Aquind Interconnector

Deadline 5 submissions

The following are summaries of the details that the Council will raise at the appropriate hearings

**Plate 2.13 – Alternative Countryside Routes (as proposed by WCC and HBC)**

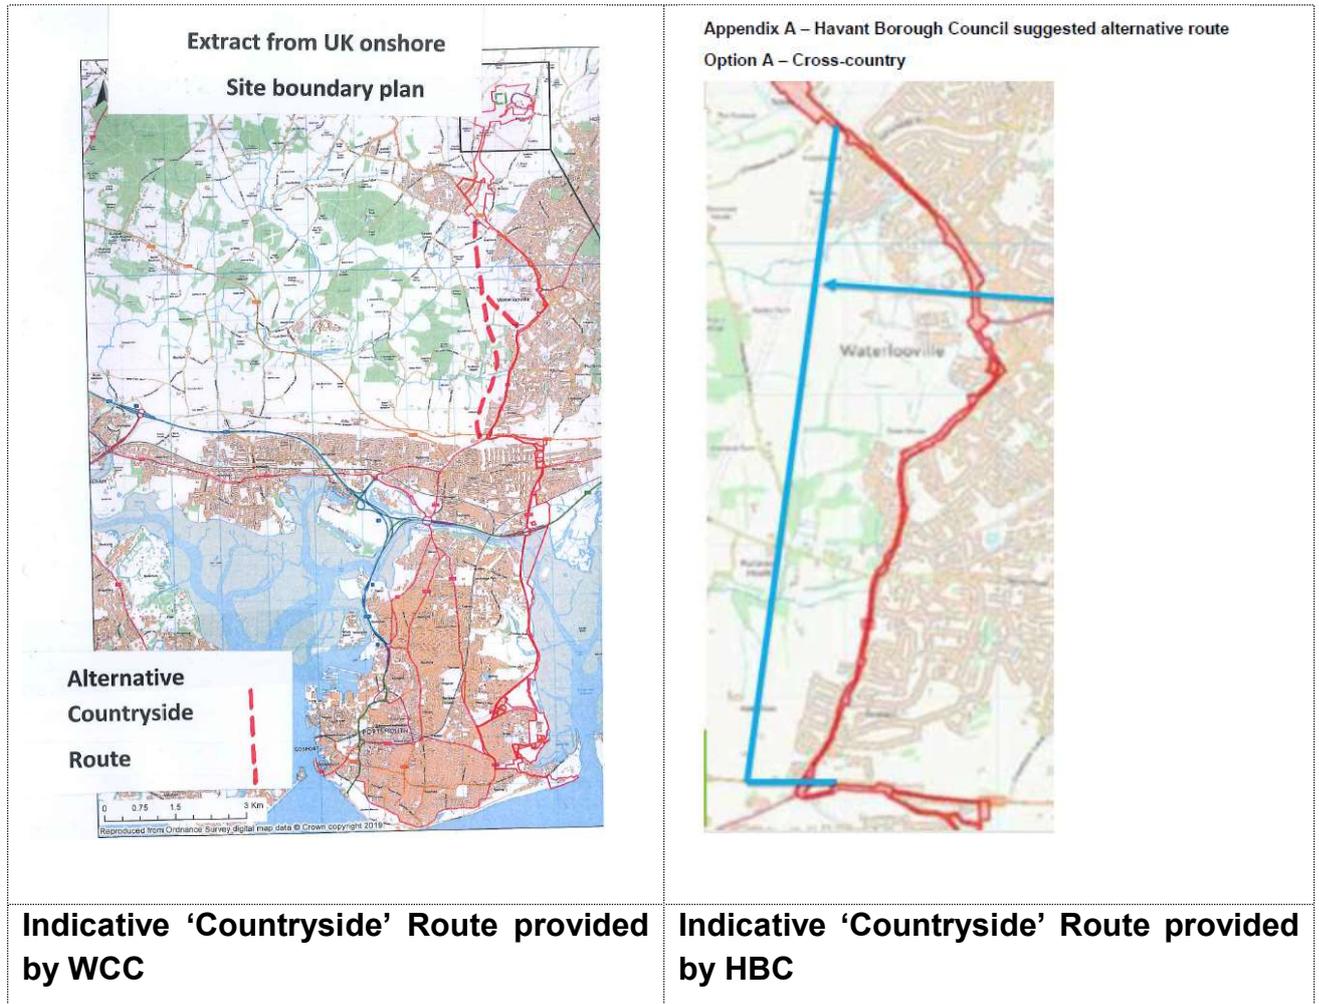
9.2.1 Winchester City Council submitted paper at procedural deadline B (PDB-006) relating to the applicant's consideration of the countryside route in the alternatives assessment (chapter 2 of the ES.) The Council notes the reference to this option on 9.2. On the basis this is a Compulsory Acquisitions hearing and the Council has not been asked directly to respond on this matter it is assumed the discussion will not encompass the merits of the countryside route against the road route.
